Appendix 6 - Prior Approval Application ref. 6/2020/0447/PN11 (subject appeal scheme) – formal response from EHO and subsequent email correspondence including response from KR Associates

Planning Consultation Memo

Date	Planning Officer	Environmental Health Officer
16/03/2020	David Elmore	Karl Riahi
Planning Application Number	Worksheet Number	
6/2020/0447/PN11	WK/116050

Application Details: Prior approval for the change of use from offices (B1(a)) to dwellinghouses (C3) to create 45 residential dwellings

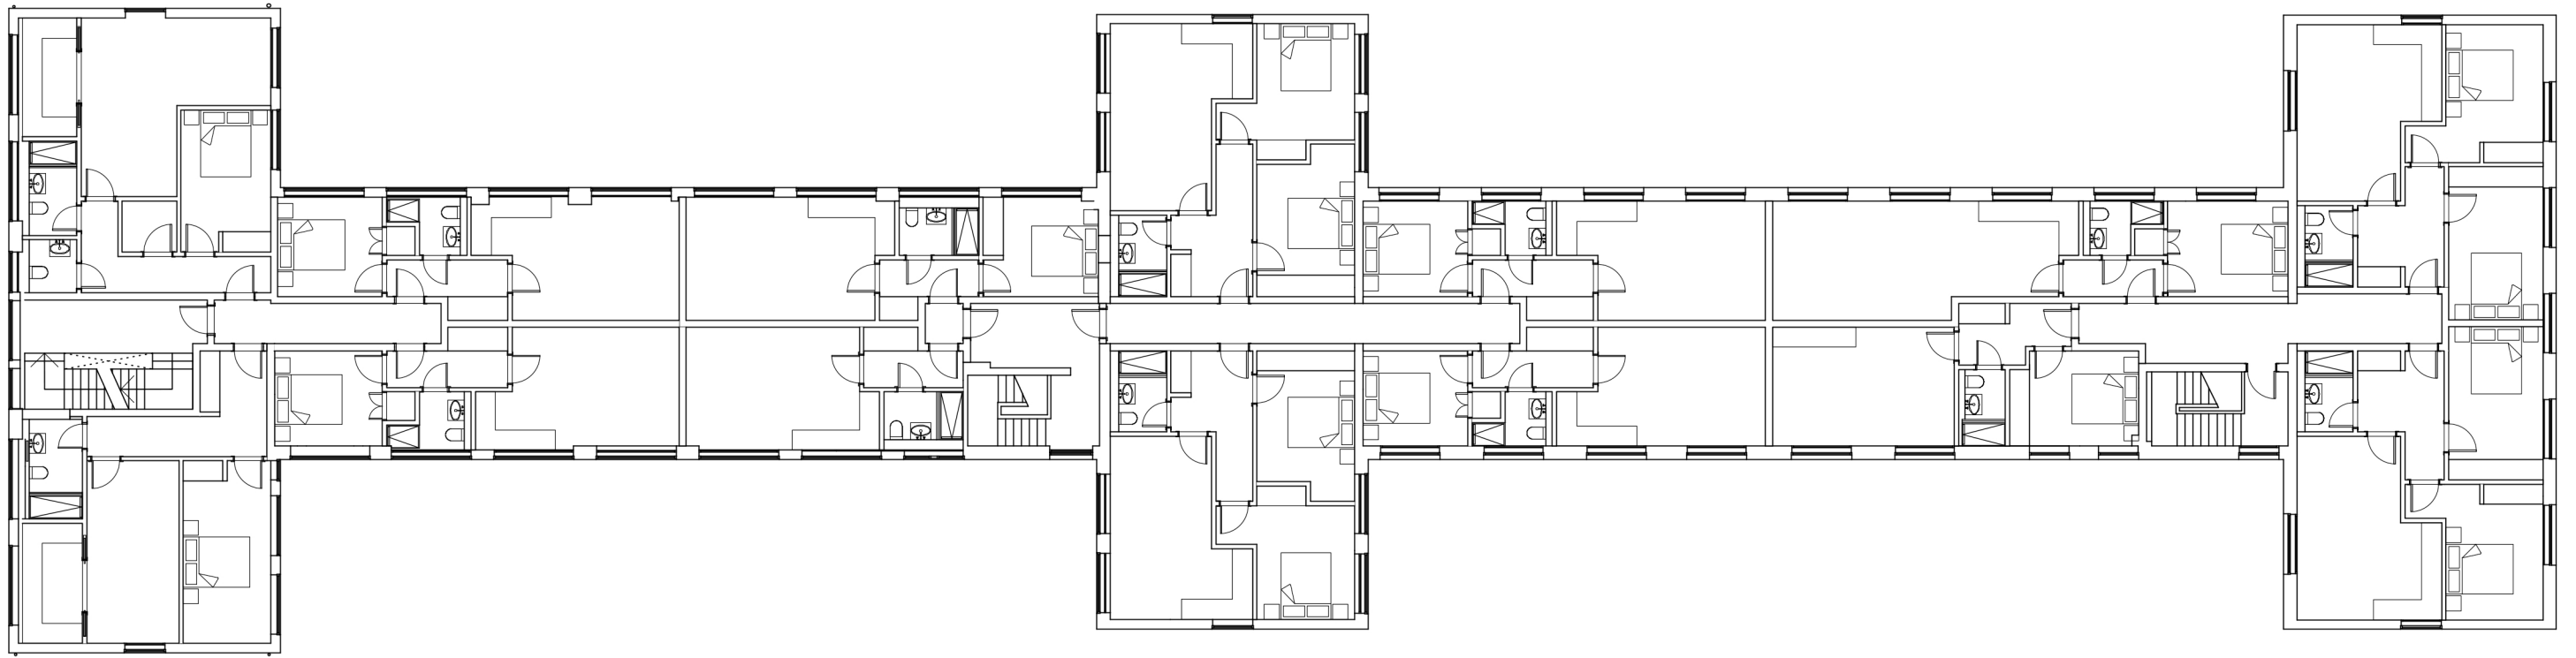
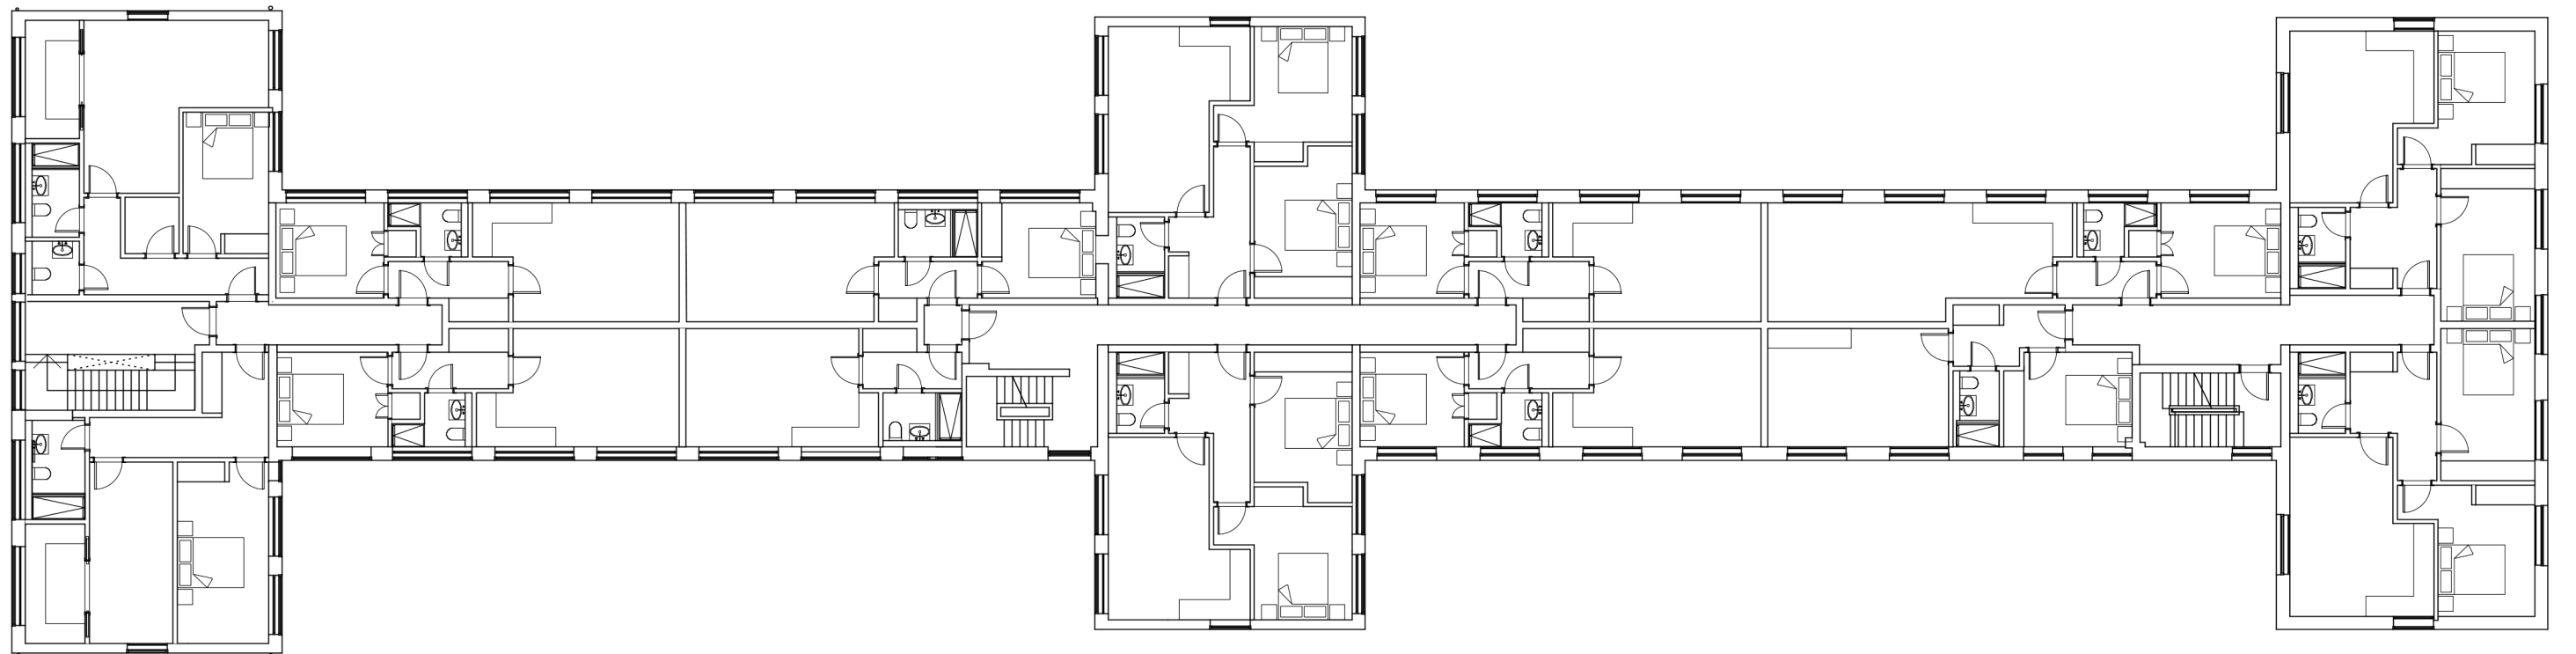
There are serious concerns regarding noise from commercial/industrial noise sources, with the report showing a 73dB LAeq external noise level, along with a 49dB internal noise level with windows open. It is unclear how this internal noise level has been calculated or which rooms it refers to, as generally it is accepted that a partially open window provides an attenuation of 10 to 15dB, which would make the internal noise level 58 to 63dB internally. This would have serious impacts on things people take for granted, such as holding a conversation or watching television.

As the west facade is predicted to be exposed to the highest noise levels (as demonstrated in KRA's noise impact assessment), we have reconfigured the internal layout of the proposed units so that non-sensitive spaces (e.g. bathrooms, stairs, hallways etc.) are located on this side of the building. These non-sensitive spaces will act as a buffer to further minimise the noise impacts on the western residential units. The revised internal layout replaces the more noise sensitive spaces that were previously proposed.
